Action Group for Campaign Against One Earth Solar Farm

Responses to Environment Agency Documents
EN010159-000562-XA-2025-100428-01 and EN010159-000563-XA-2025-100427-01

To: The Planning Inspectorate, 16th September 2025

Subject: Responses to Environment Agency Documents EN010159-000562-XA-2025-100428-01 and EN010159-000563-XA-2025-100427-01

Drawing Title:
Surface Water Drainage Strategy
Western BESS Compound

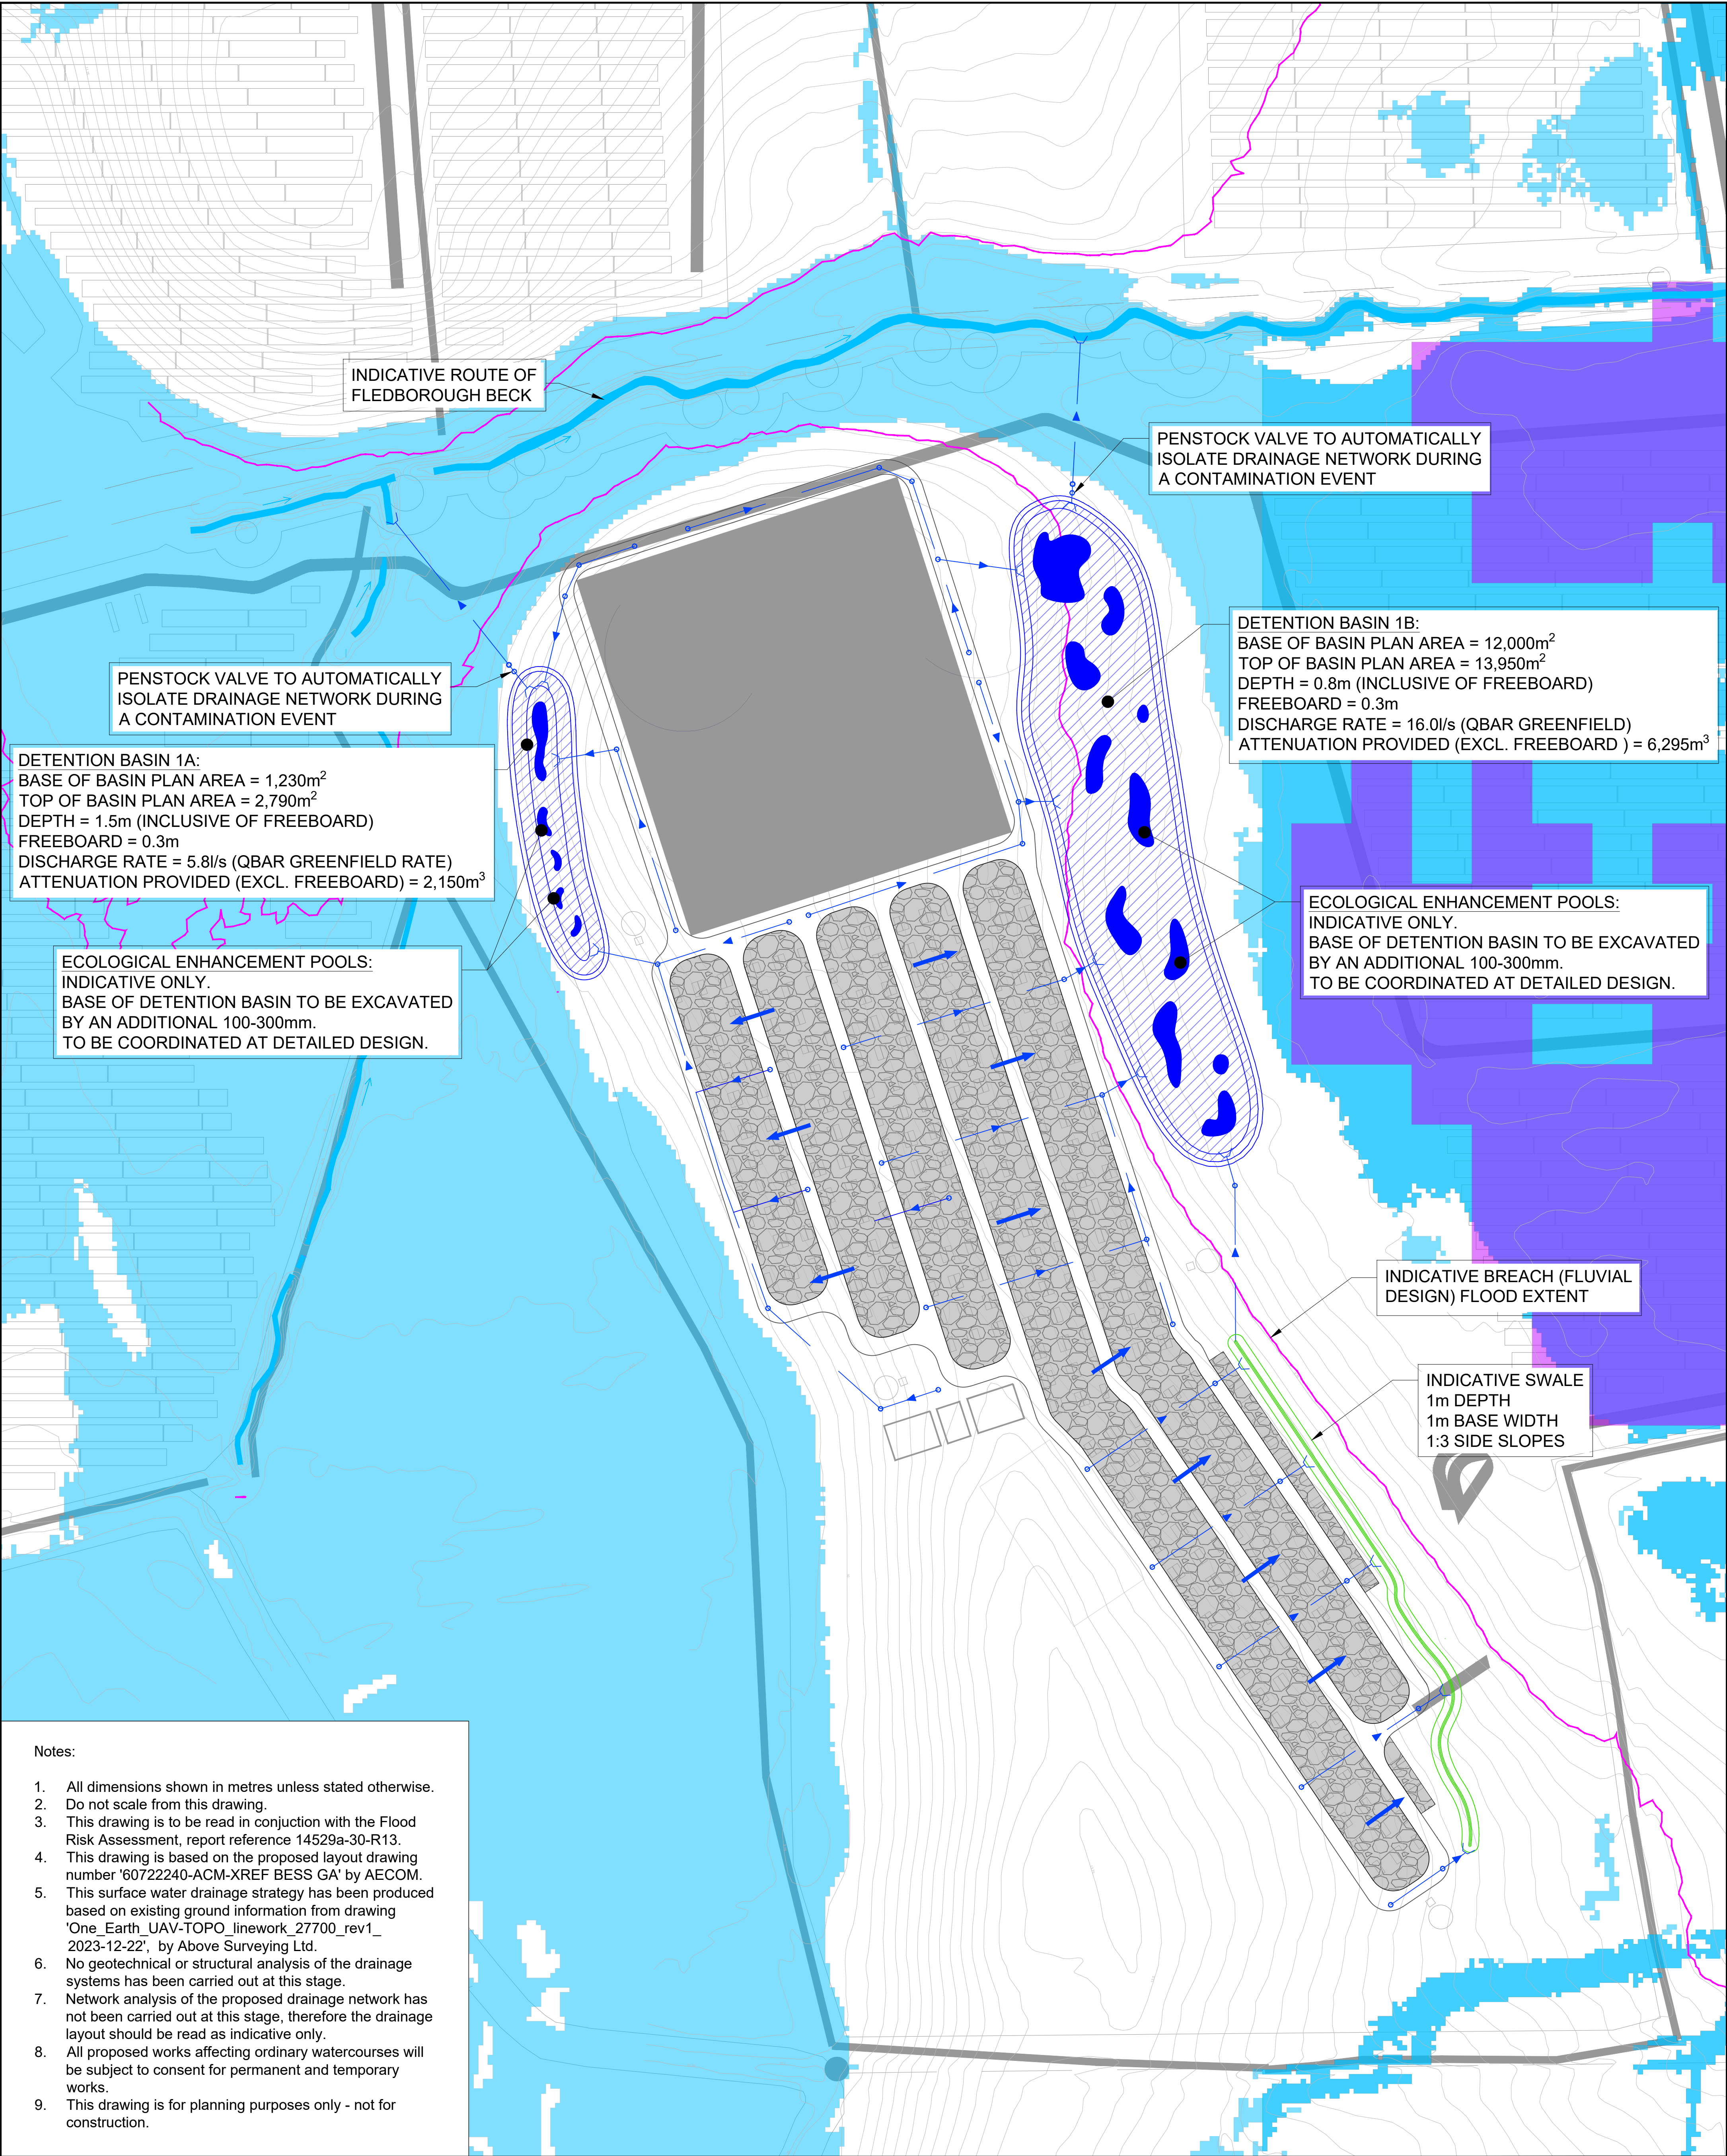
The eastern BESS site lies at a low elevation of just seven metres above mean sea level, also raises concerns over what effects of a flood event would be, and whether the drainage systems will function effectively under adverse conditions.

- 4) The attenuation basins have been sized to accommodate the volume of runoff generated by a 1 in 10 year rainfall in addition to 228 m3 of firewater with no resultant discharge to surrounding environments.

Our Answer: We are concerned about this answer. Typically a single fire appliance would deliver a steady 2,000 L/min, therefore it would use 228 cubic metres of water in 1.9 hours. Firstly, this does not take into consideration real life situations, or new recommendations – but instead is based on bare-minimum and out of date advice. Also, this leaves no room for items 2 or 3, i.e. suppression water and water to cool adjacent units.
